**East Midlands Gateway
Phase 2 (EMG2)**

Applicants' Response to Examining Panel's Second Written Questions

JUNE 2026

The East Midlands Gateway Phase 2
and Highway Order 202X and The East Midlands Gateway
Rail Freight and Highway (Amendment) Order 202X

L57 SHARED USE CYCLE TRACK PROFILE
SCALE: H 1:2500, V 1:500. DATUM: 55.000

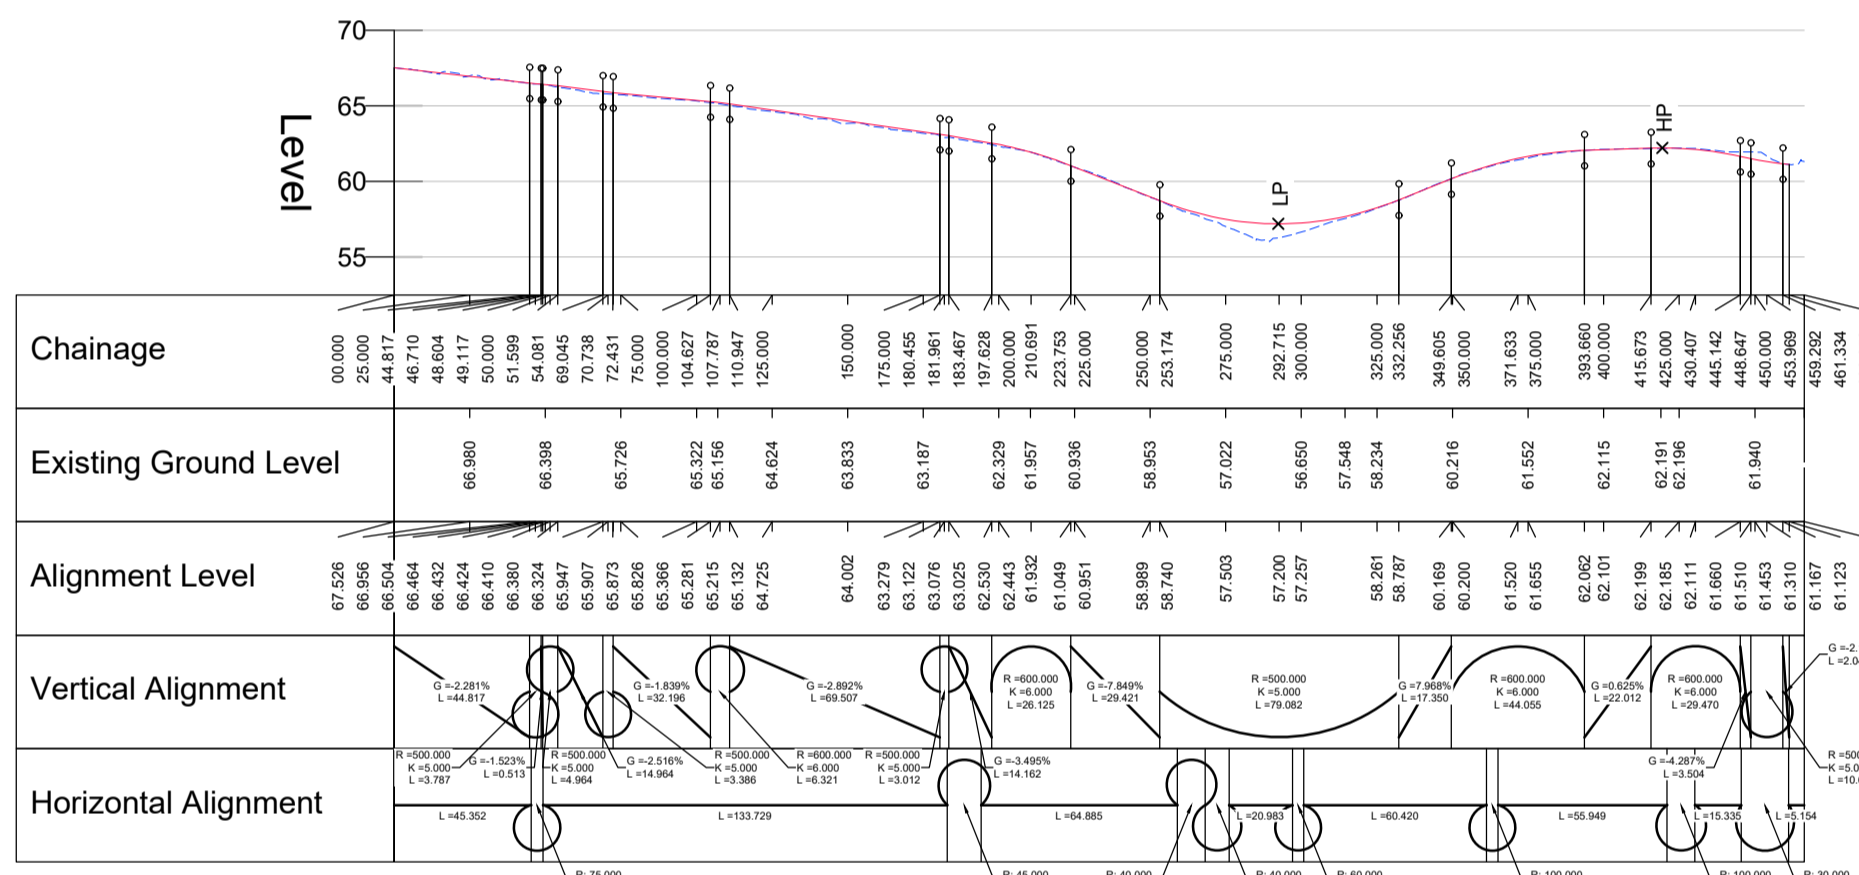
Q2.0.2	The applicants	<p>Work no. 19</p> <p>In the 'Applicants' Post Hearing Submissions (PM, CAH1, ISH1 and ISH2) [REP1-052] item 6, when discussing Work No. 19 it is stated the works "relate to an upgrade of the existing footpath L57 running westwards from EMG1 to Castle Donington to deliver commuter cycle connectivity. The most direct route from Castle Donington to EMG2 is via footpath L57".</p> <p>Could the applicants' please explain how it is intended to facilitate access across the bund for cyclists to the west of</p>	<p>The active travel route between L57, EMG1 and EMG2 would not use the stepped footpath over the bund near Plot 16.</p> <p>The route would go along the EMG1 estate road and use the shared use footway cycleway over the bund that was built to connect EMG1 to Diseworth Lane. This route is a permissive cycle track as defined in the EMG1 DCO and shown between points 34-35-36-21-37 on the EMG1 Access and Rights of Way Plans Sheets 4 and 5 (EMG1 Documents 2.3D and 2.3E). Copies of these plans are provided at Annex 2A.</p>

ExQ2	Question to:	Question:	Applicant's Response
		Plot 16 given the current steps over the bund and the existing gradients, particularly as it is said that the "route from L57 ties in with the wider cycle improvements on the A453 between EMG1 and EMG2".
